Title	Deadline 4 Noise Responses		
Project	Gatwick Airport DCO		
Reference	28AD.NT.5.0	Author(s)	BHo
Date	30 May 2024	Reviewer	VC

1. The Applicant has updated their proposed Noise Insulation Scheme [REP4-017]; this note sets out further clarifications sought. **Table 1** sets out summaries of issues identified by Suono.

Title:
Ordnance Survey Base Map Identifying Category 3 and Noise Insulation Scheme Boundary - Sheet 2 of 4

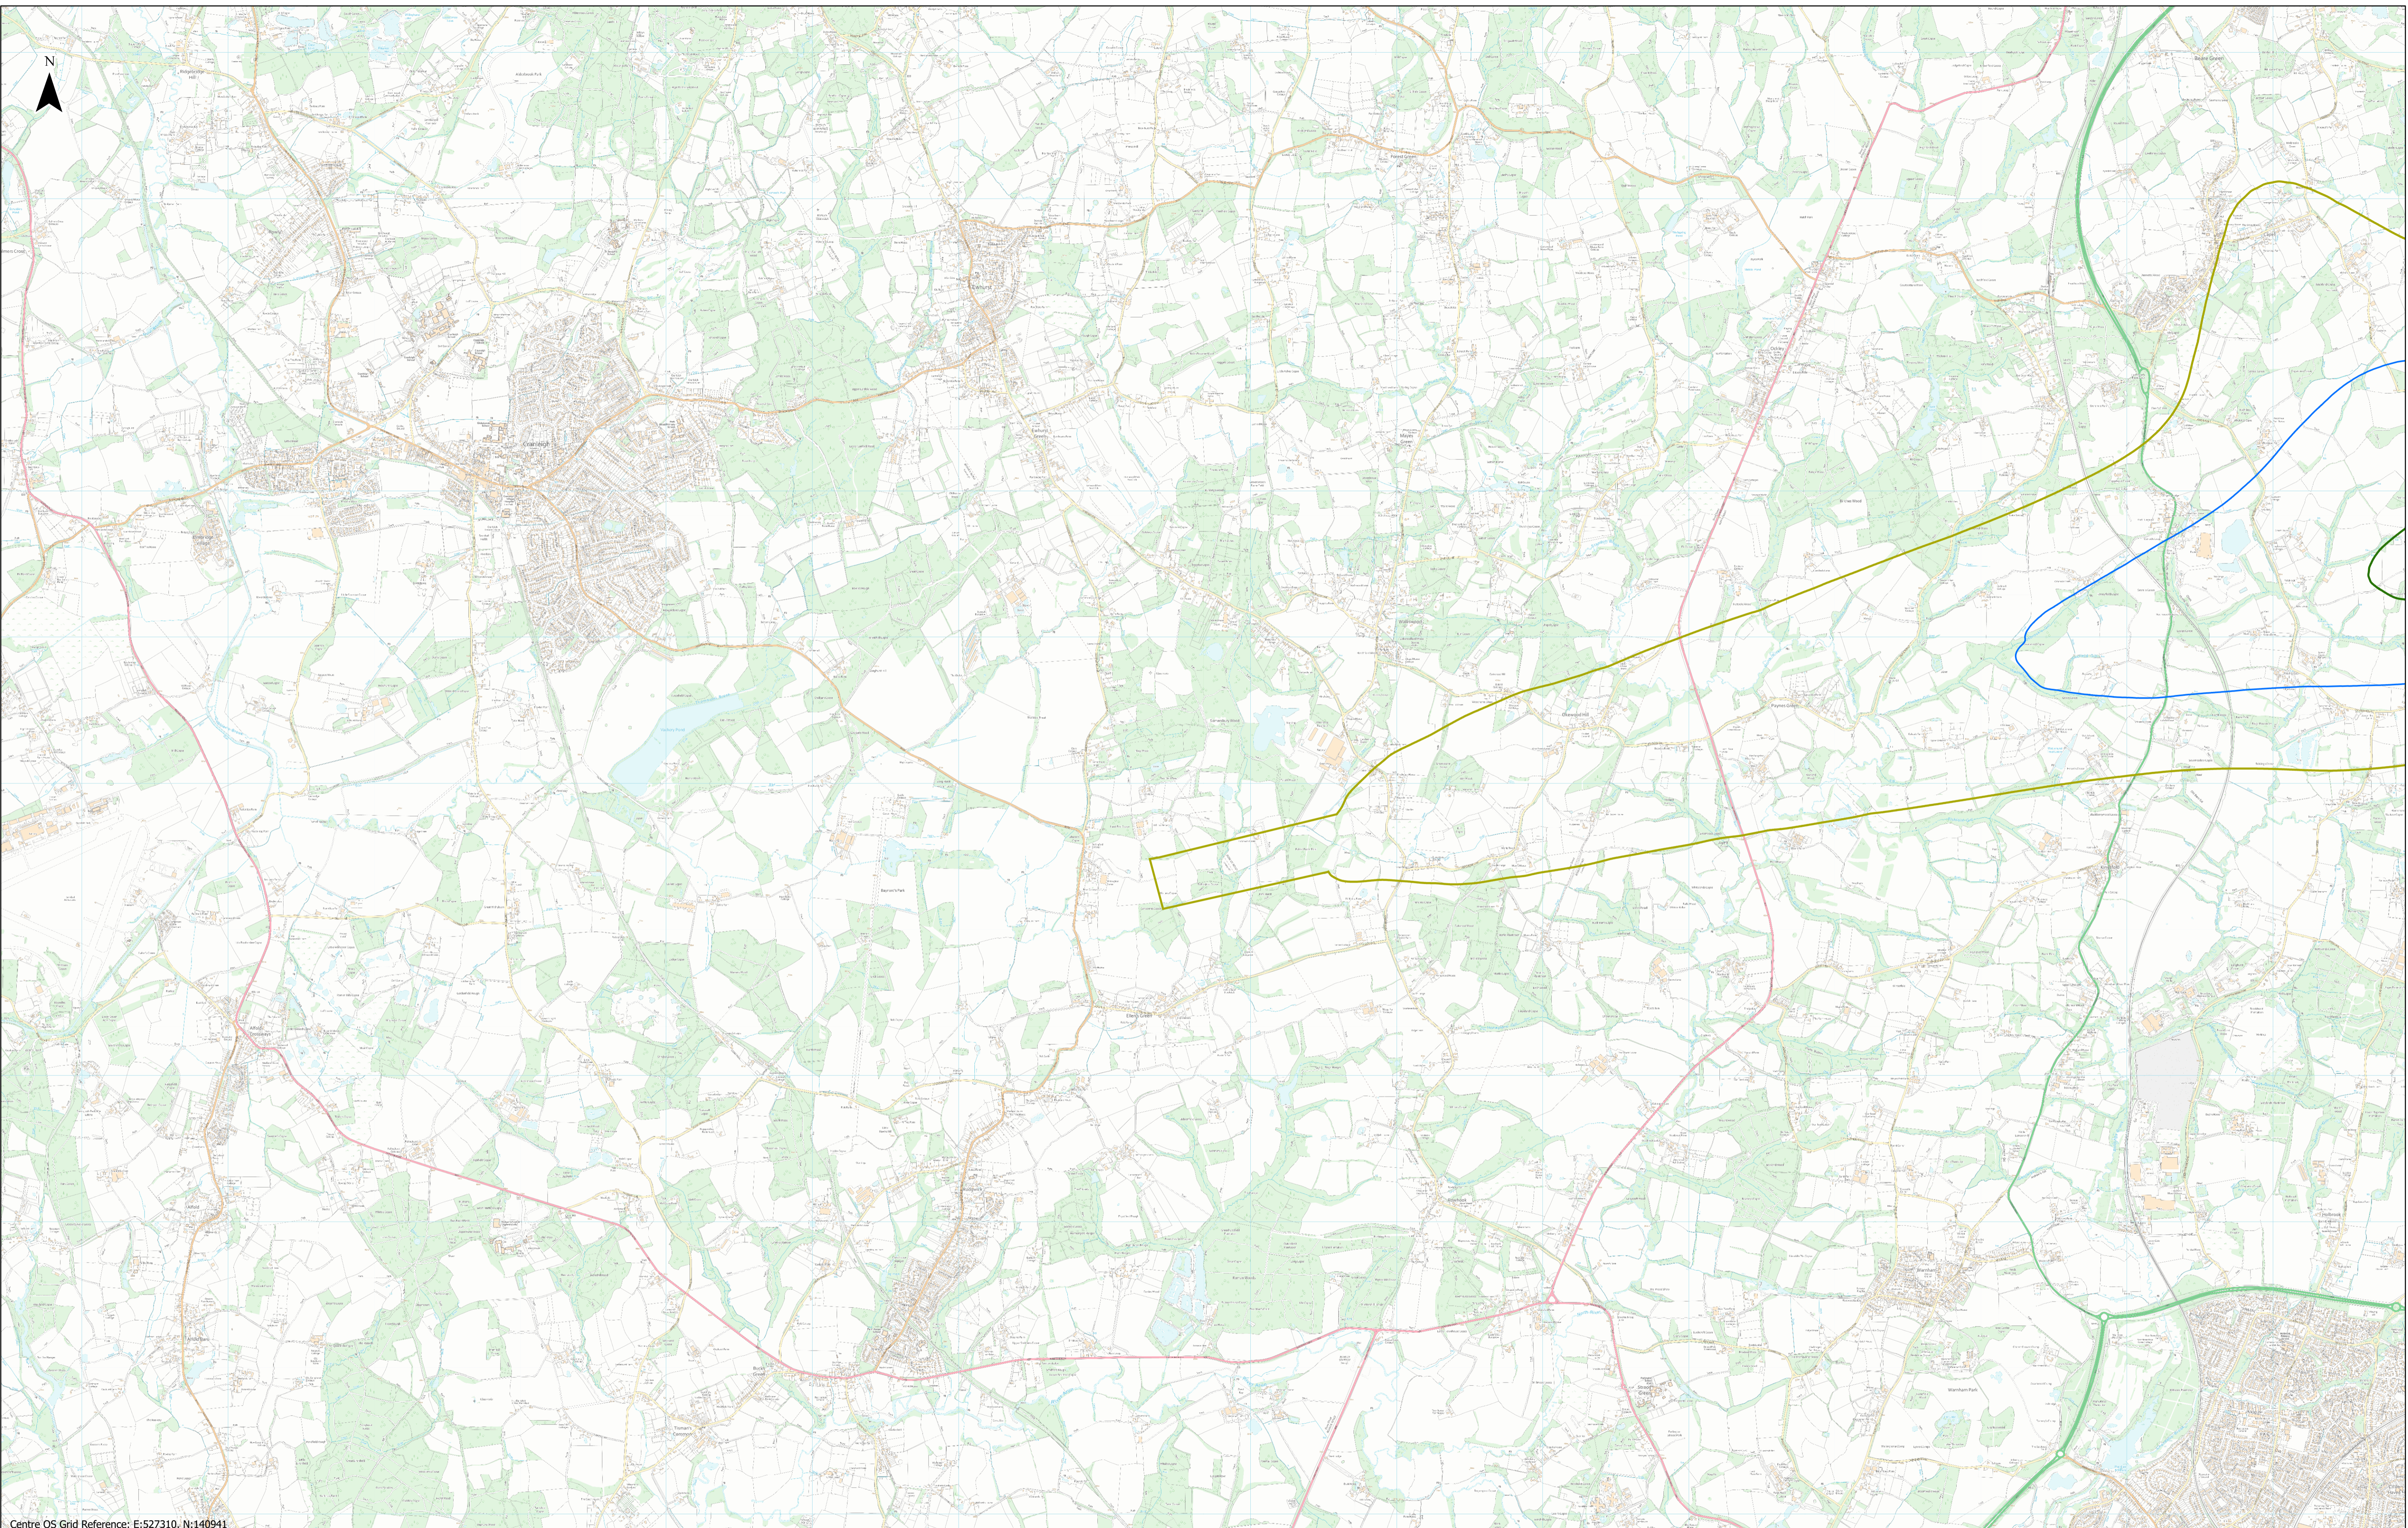
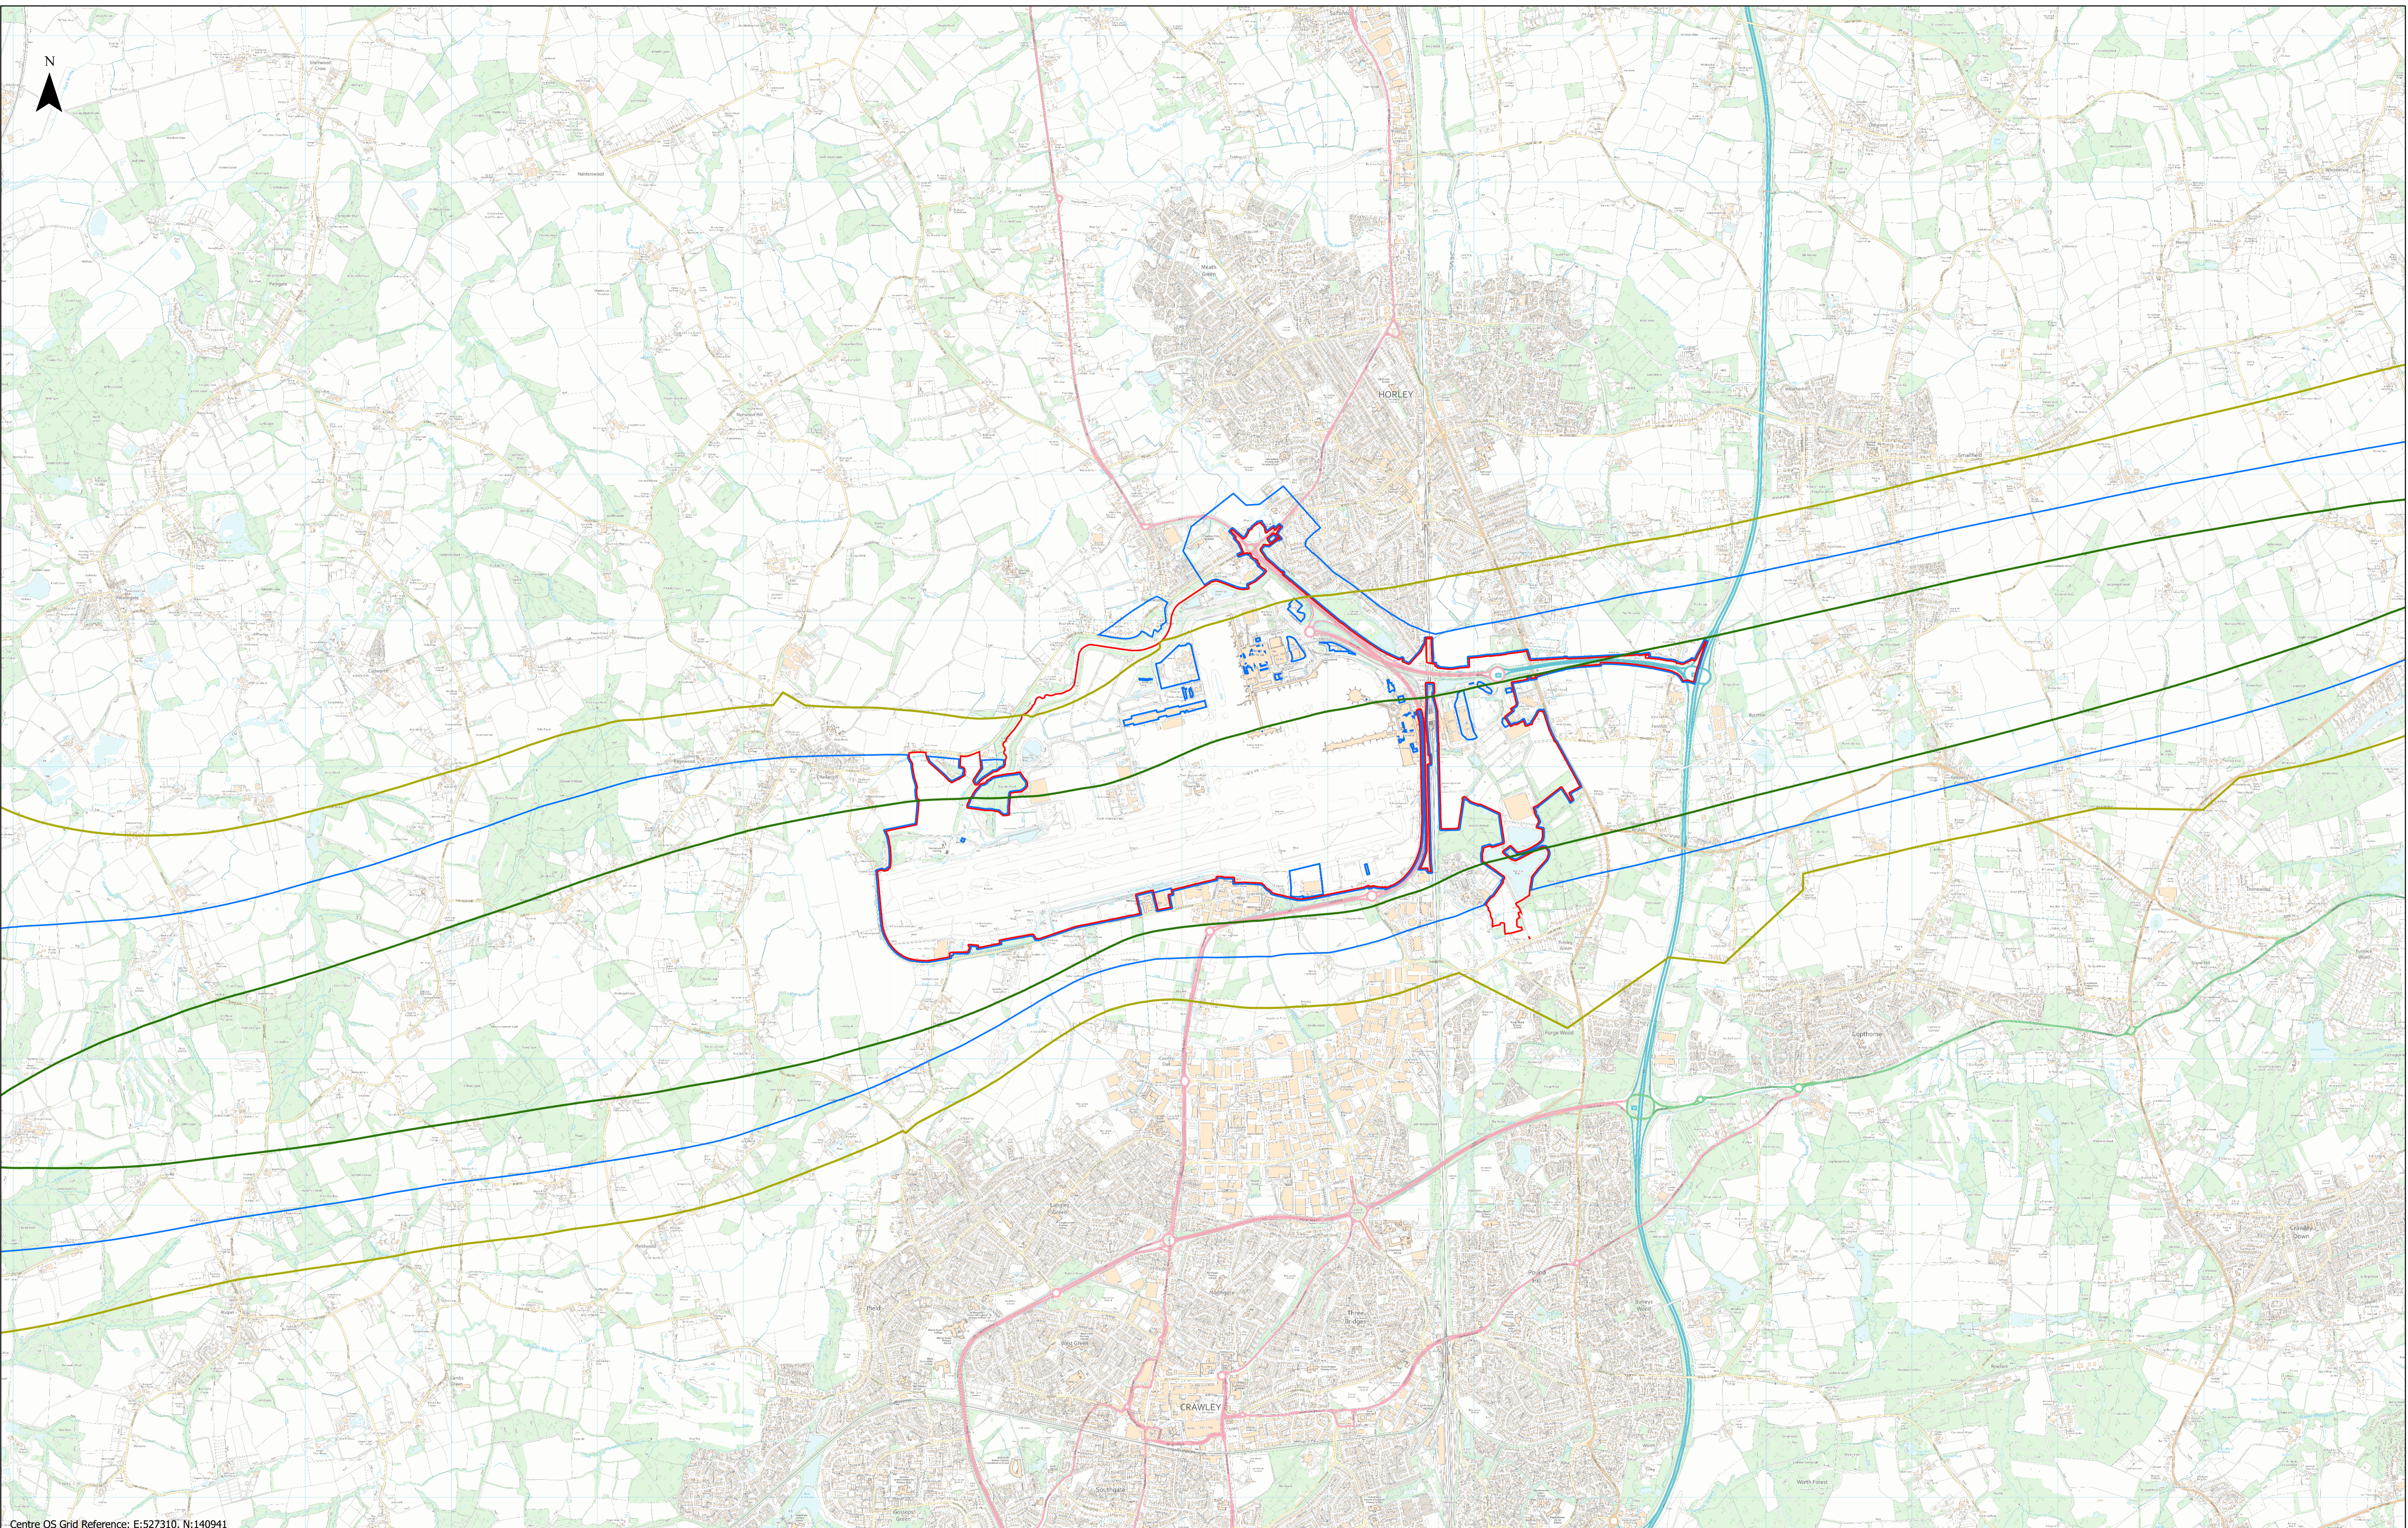
The SOAEL contour figures provided in in Appendix 2 of Appendix B in REP3-071 would suggest both Oakfield Cottages and Lowfield Heath fall just outside the Inner Zone and would likely be inside the Outer Zone and as such are eligible for noise insulation at a far earlier stage than when the Applicant proposes to review the matter.

Untitled contour figure on final page. The figure should be replicated on a map where dwellings are clearly identifiable, to demonstrate which could benefit from mitigation. A website is not a suitable replacement, as this is not traceable in the same way as submitted documents are.

The Zones should also be expanded around settlements bisected by the Zones' boundaries. This would help ensure that certain situations do not occur, such as residents living on either side of the road receiving differing levels of mitigation, or some receiving mitigation while their neighbours do not.
